BIGOTRIES

6985 N. MERIDIAN RD
PEYTON, CO 80831
EL PASO COUNTY, COLORADO

Markup Summary

10 SITE PLAN
SCALE: 1"=30'-0"

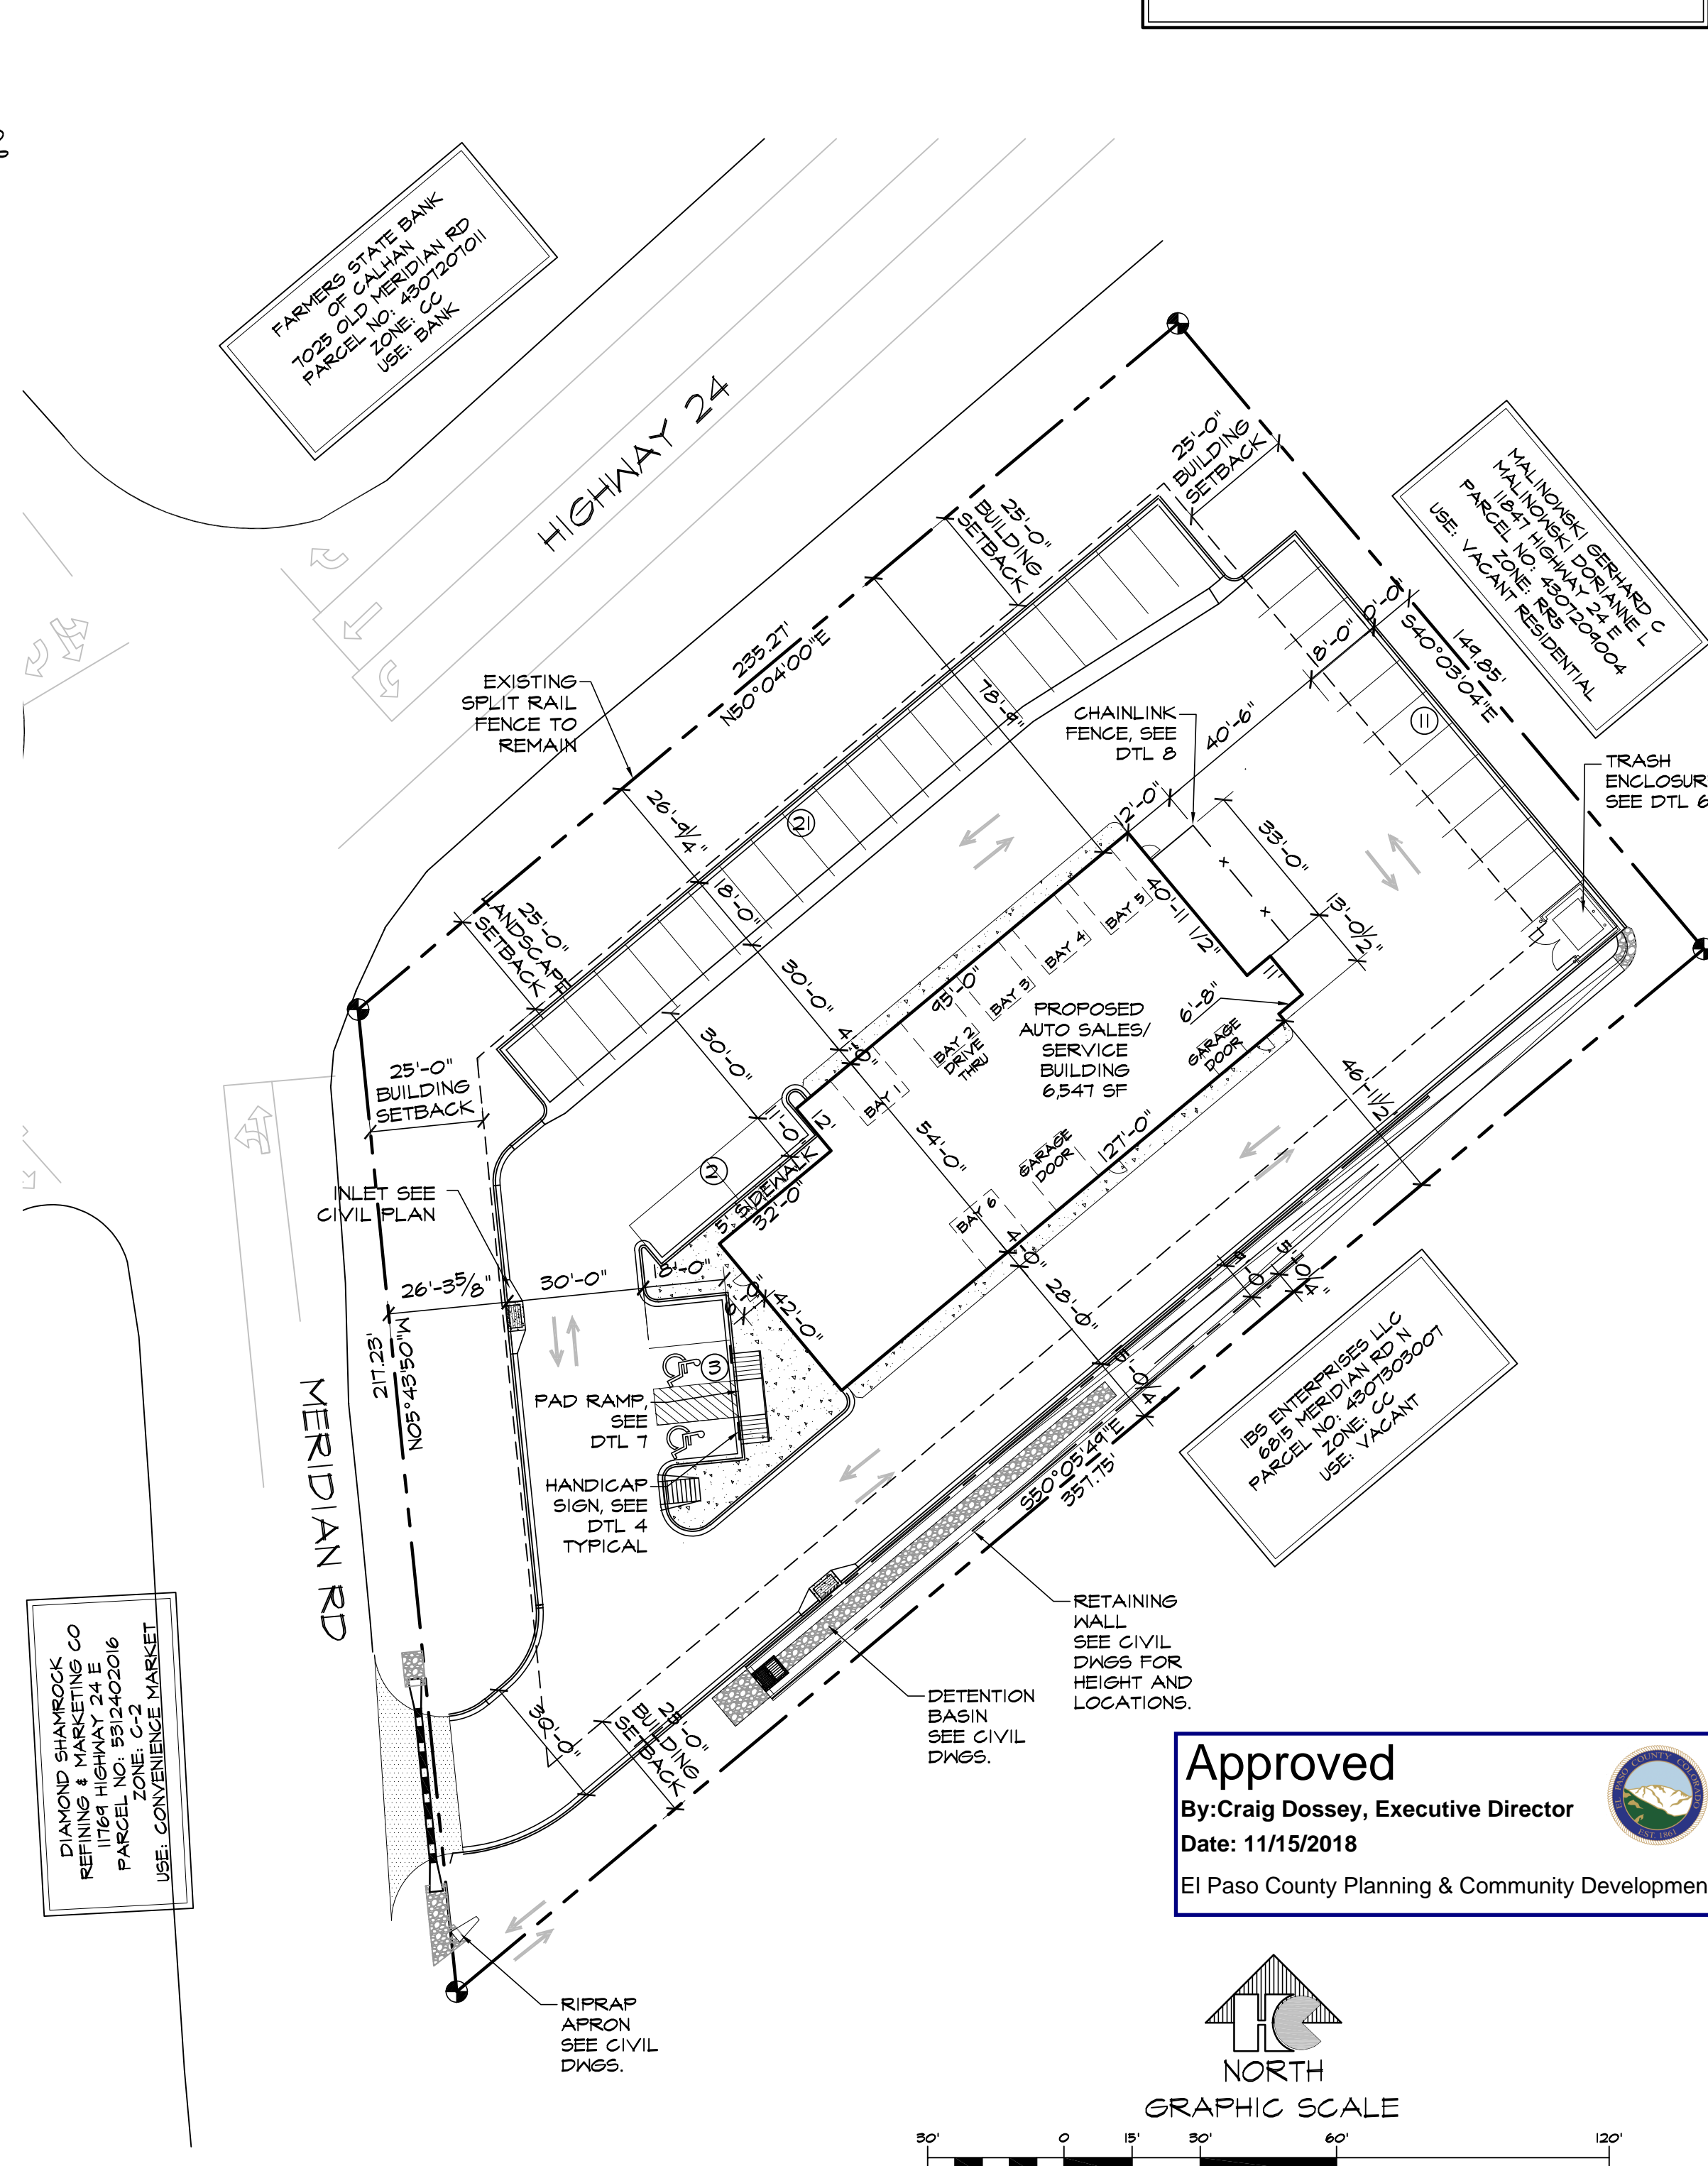
Include ADA Note and Route
